# HAY CREEK VALLEY

SITUATED IN THE SOUTHEAST QUARTER OF SECTION 33 AND THE SOUTHWEST QUARTER OF SECTION 34,  
TOWNSHIP 11 SOUTH, RANGE 67 WEST OF THE SIXTH PRINCIPAL MERIDIAN,  
COUNTY OF EL PASO, STATE OF COLORADO.

PCD FILE # SF2324

### LOT EASEMENT TYPICAL

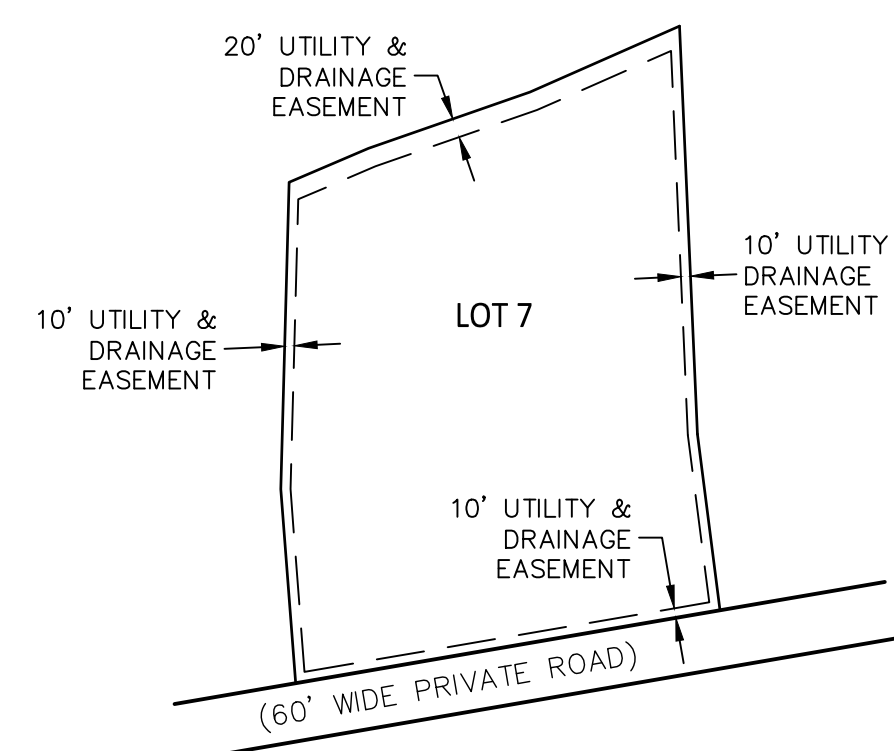
33. ABSORPTION FIELD MUST BE LOCATED A MINIMUM OF 100 FEET FROM ANY WELL, INCLUDING THOSE ON ADJACENT PROPERTIES. ABSORPTION FIELDS MUST ALSO BE LOCATED A MINIMUM OF 50 FEET FROM ANY DRAINAGES, FLOODPLAINS, OR PONDED AREAS AND 25 FEET FROM DRY GULCHES. PLEASE ADD NOTE IN REGARD TO ON-SITE WASTEWATER SYSTEMS.

The private roads as shown on this plat will not be maintained by El Paso County until and unless the streets are constructed in conformance with El Paso County standards in effect at the date of the request for dedication and maintenance.

added

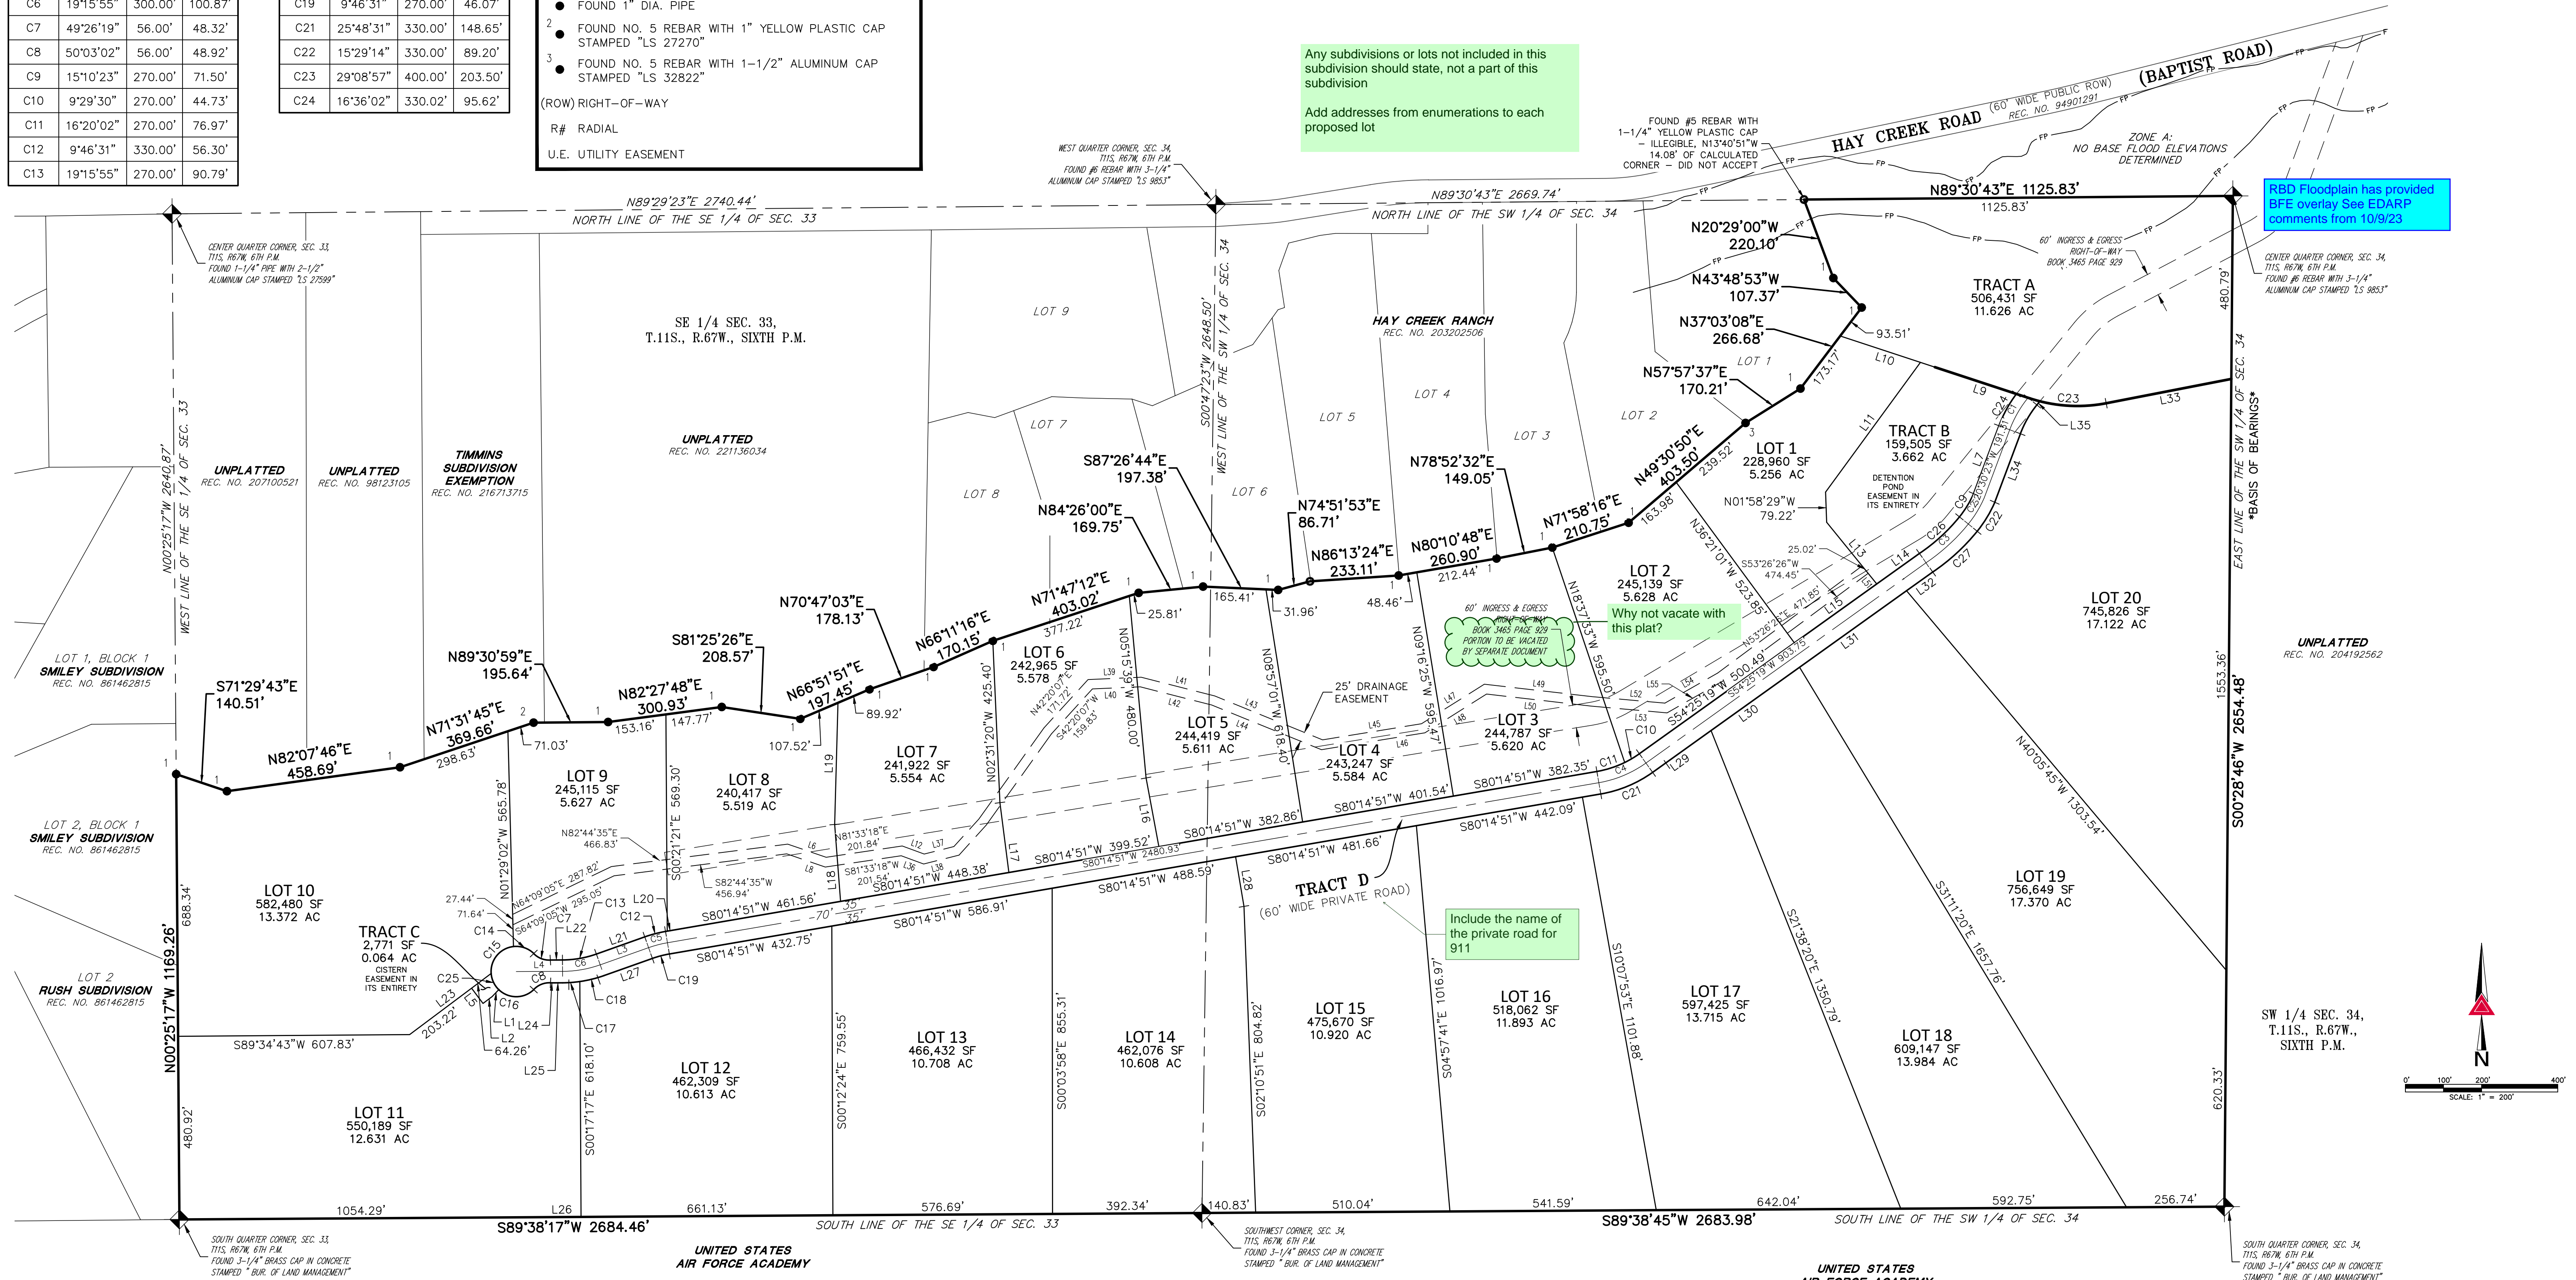
Any subdivisions or lots not included in this subdivision should state, not a part of this subdivision

RBD Floodplain has provided BFE overlay See EDARP comments from 10/9/23

addresses added

added

added

added
